WEST SUSSEX COUNTY COUNCIL CONSULTATION

TO:	Arun District Council - FAO: Anita Gardner
FROM:	WSCC - Highways Authority
DATE:	24 May 2021
LOCATION:	Land rear of Paynters Croft, Burndell Road, Yapton, BN18 0HR
SUBJECT:	F/5/21/PL Erection of 23 No. dwellings. This application is a Departure from the Development Plan & is in CIL Zone 3 & is CIL Liable as new dwellings.
RECOMMENDATION:	More Information

Drawing Title	Access Overview and Visibility Splays
---------------	---------------------------------------

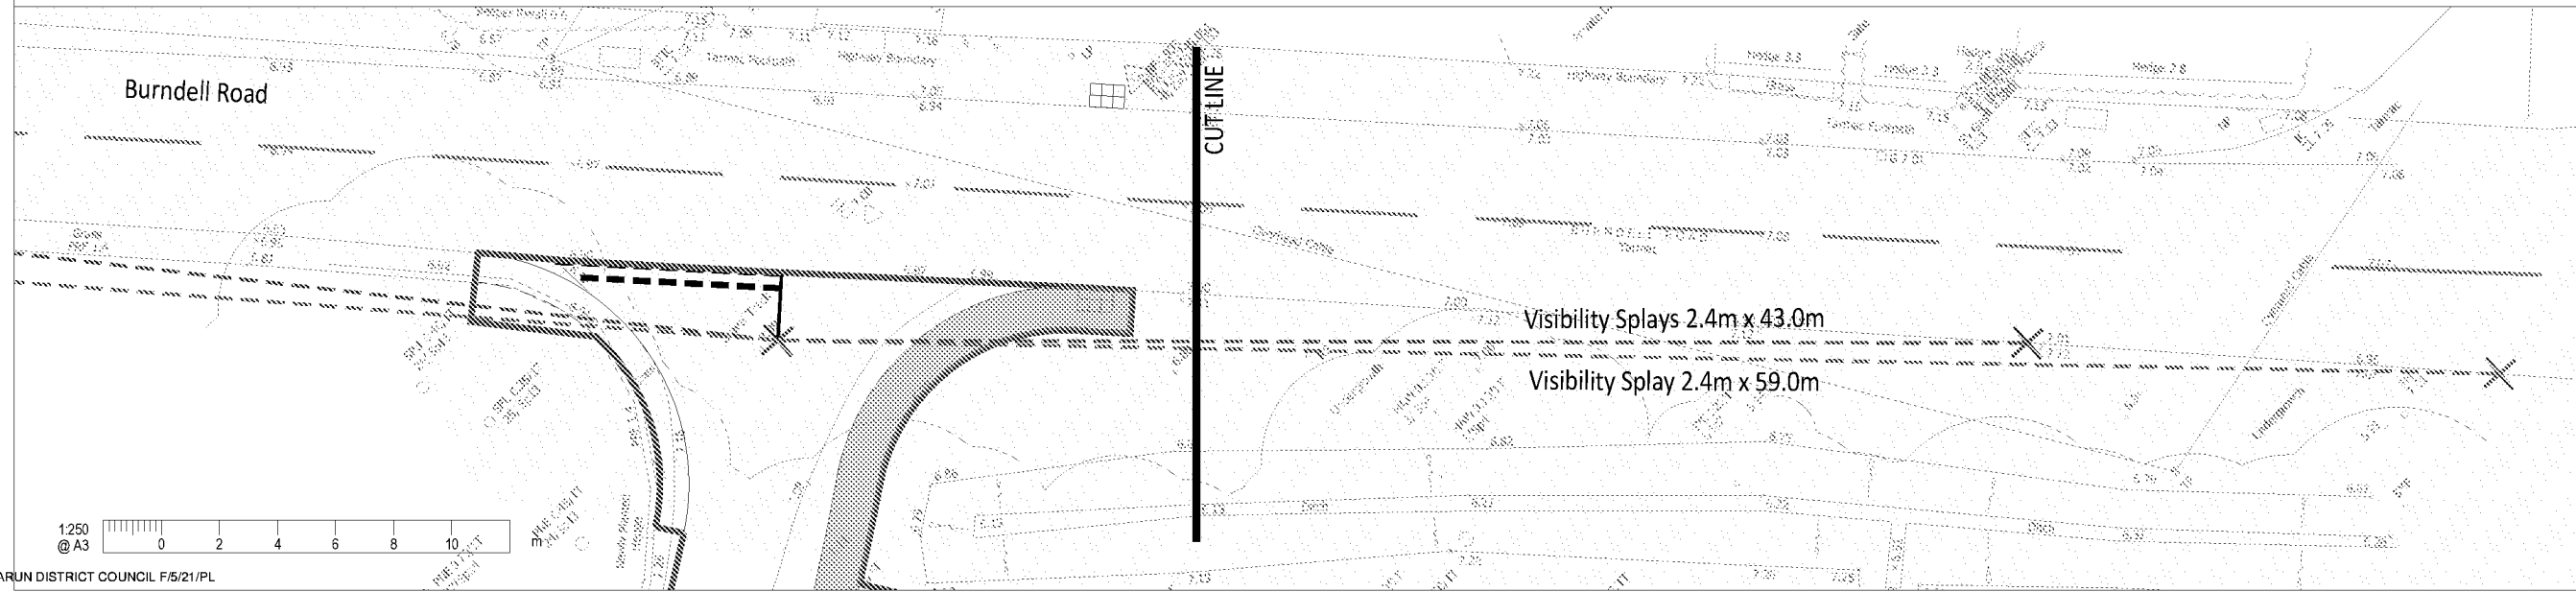
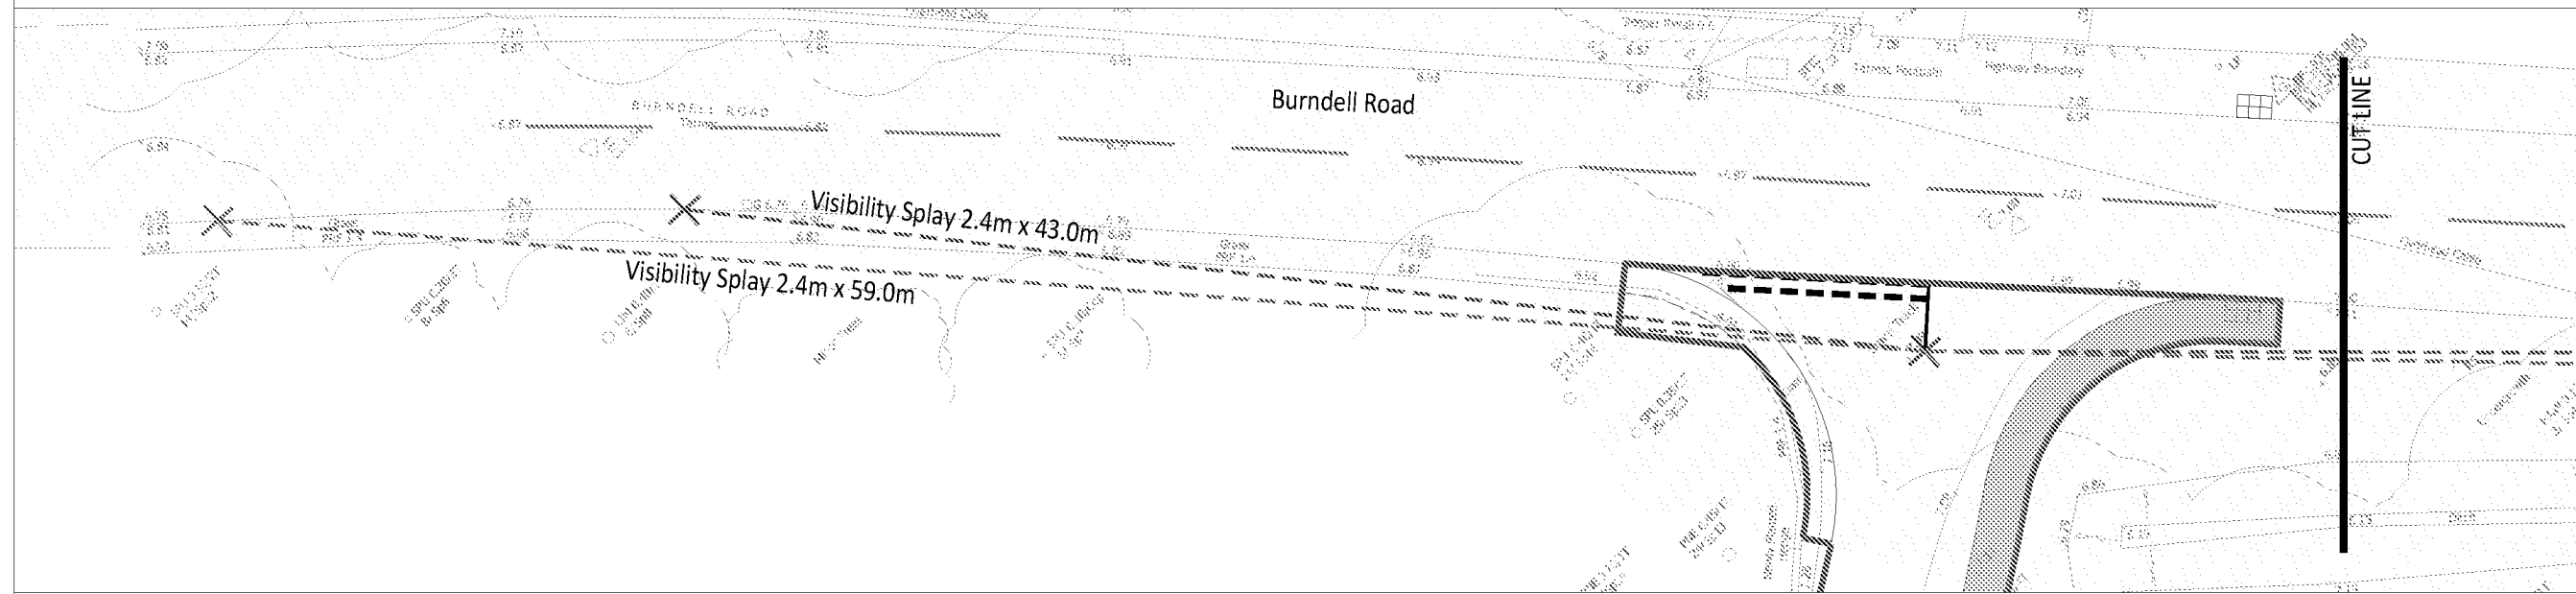
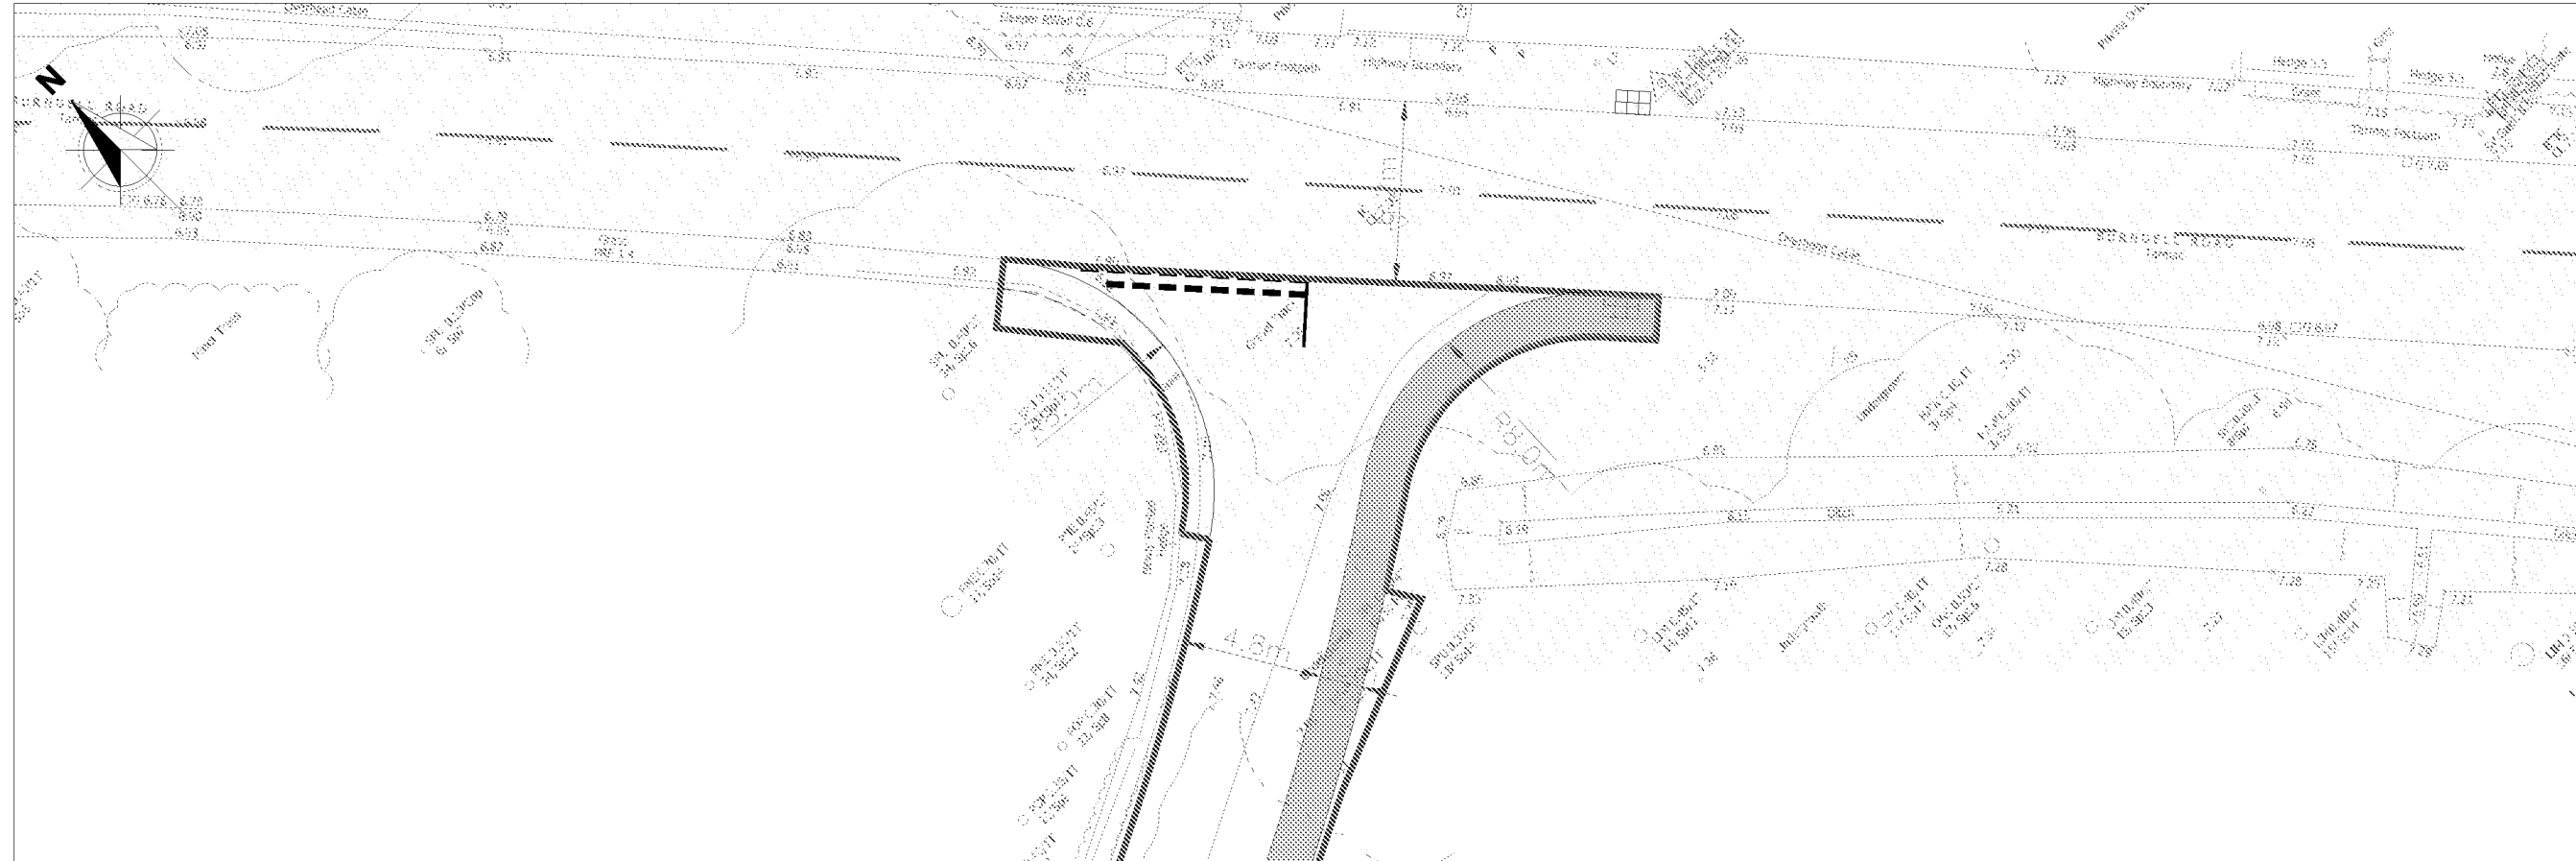
ATC surveys taken during lockdown periods are acceptable for use in calculating 85th percentile speeds and concurrent visibility splay requirements but should not be used for traffic volume counts. The TS has taken a different approach where splays concurrent to the speed limit of 30mph and to a maximum design speed of 60kph (37.3mph) have been demonstrated. As speeds could be varying and above 37.3mph a 7 day speed survey is required to ascertain the up to date 85th percentile speeds in either direction, in vicinity of the access, along with amended vehicle visibility and pedestrian forward visibility splays in accordance with these recorded speeds.

- Stage 1 RSA and Designers Response.
- Seven day ATC Speed Survey to ascertain 85th percentile speeds and demonstration of required vehicular visibility and pedestrian forward visibility splays in accordance with these.
- Exploration of providing a pedestrian/ cycle link from within site to adjacent northern site and ensure extent of internal footway on Block Plan matches with access plans.

Proposed Access Road

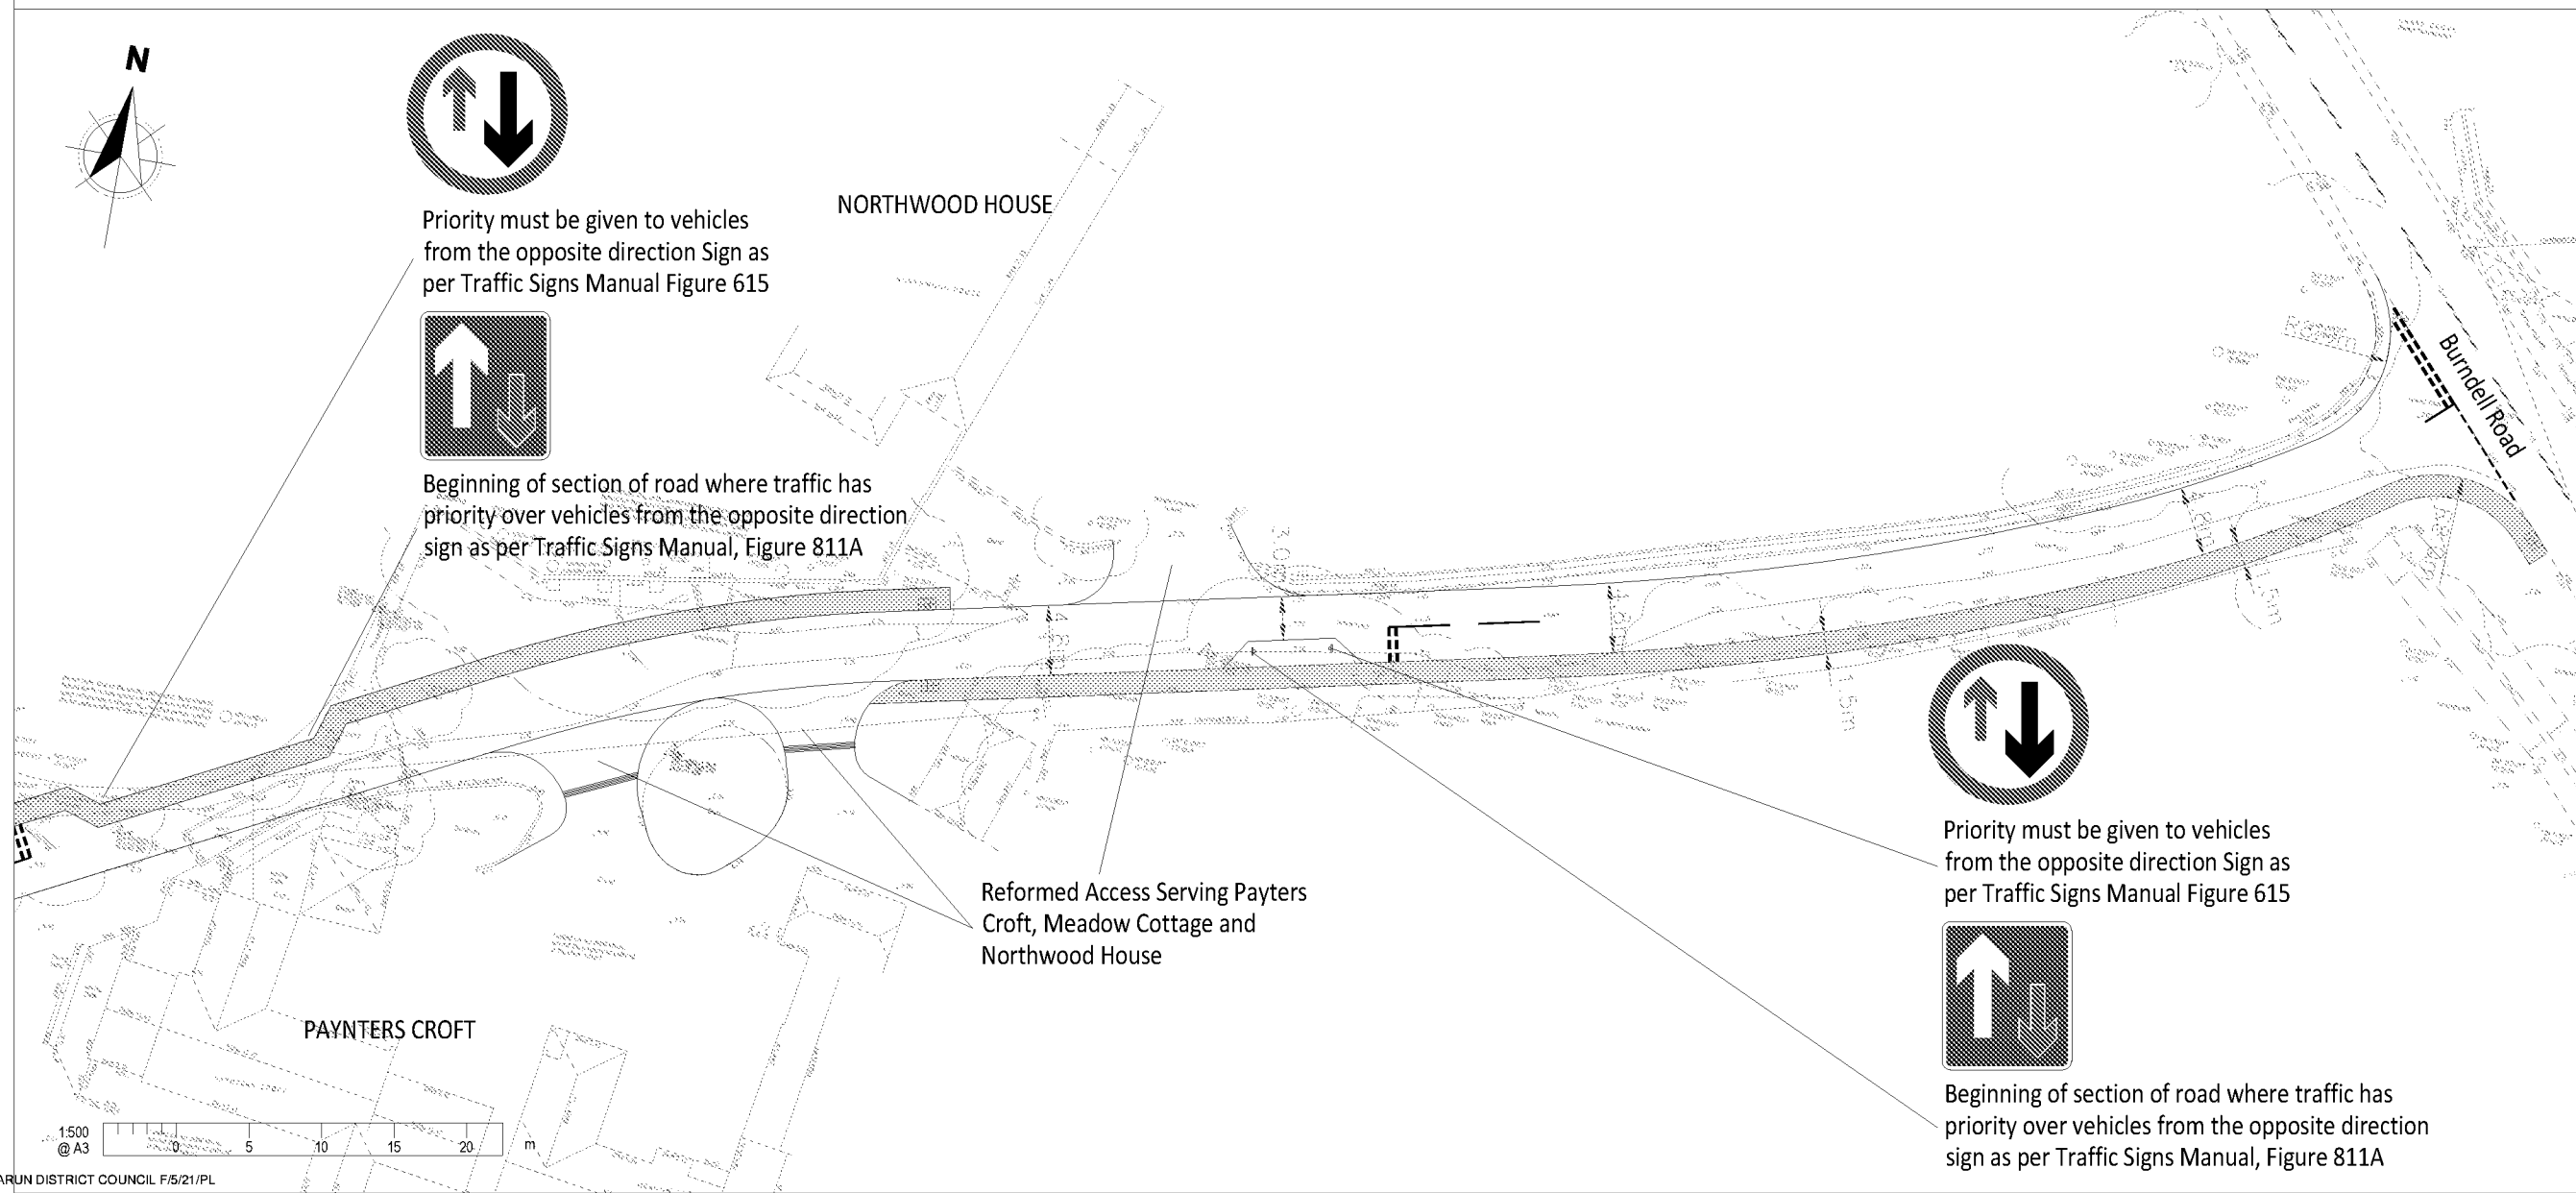
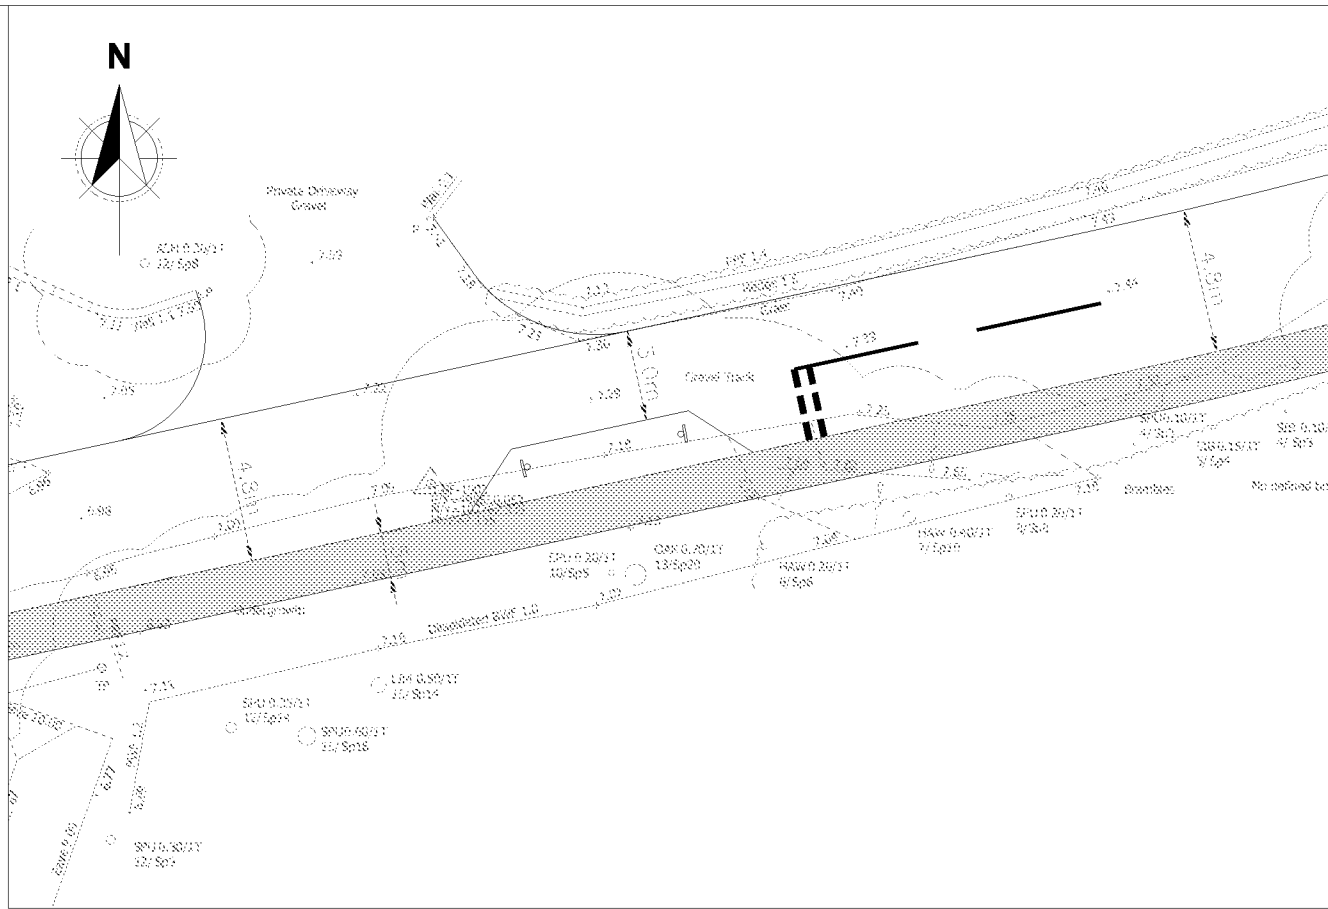
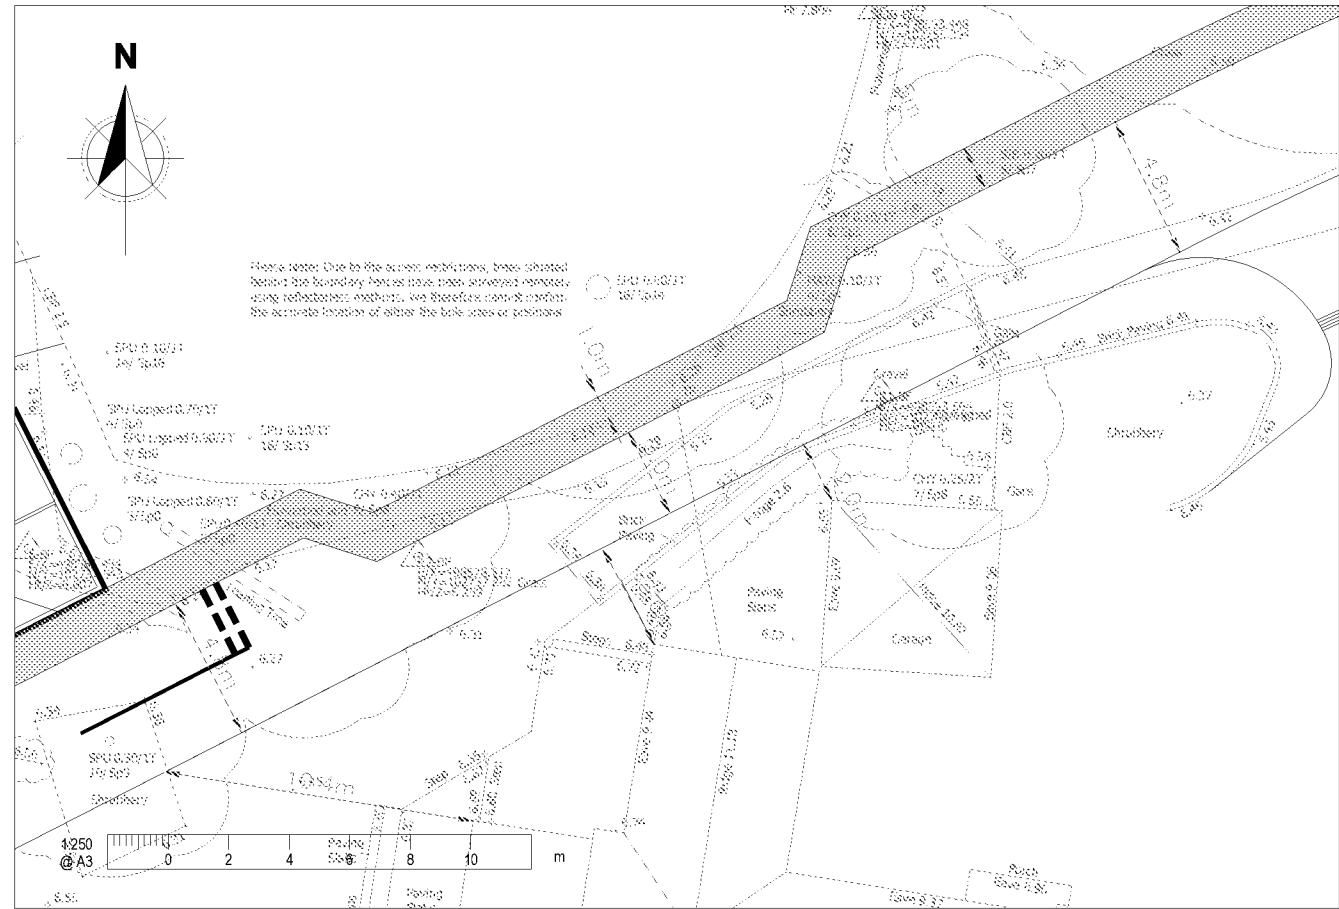
The existing private driveway will be widened to min. 4.8m with min 1.5m footway and where the access joins with public highway will take the form of a t-junction bellmouth with 8m corner radii. The footway would adjoin southern side of access road and extend to site access with an uncontrolled pedestrian crossing proposed to reach the existing footway network on opposite side of B2333.

The internal access road will feature a segregated footway on southern side (extending from public highway) which will switch to northern side along the access road and in to the site (facilitated by uncontrolled pedestrian crossing). Build outs and give way markings/signing will control vehicle speeds. The Block Plan appears to show footway merging with carriageway prior to entering the site. However, the detailed access plans show this continuing past plot 1 and 2 and merging to shared surface within the cul-de-sac and more lightly trafficked areas. The applicant should confirm and ensure all plans are matching.
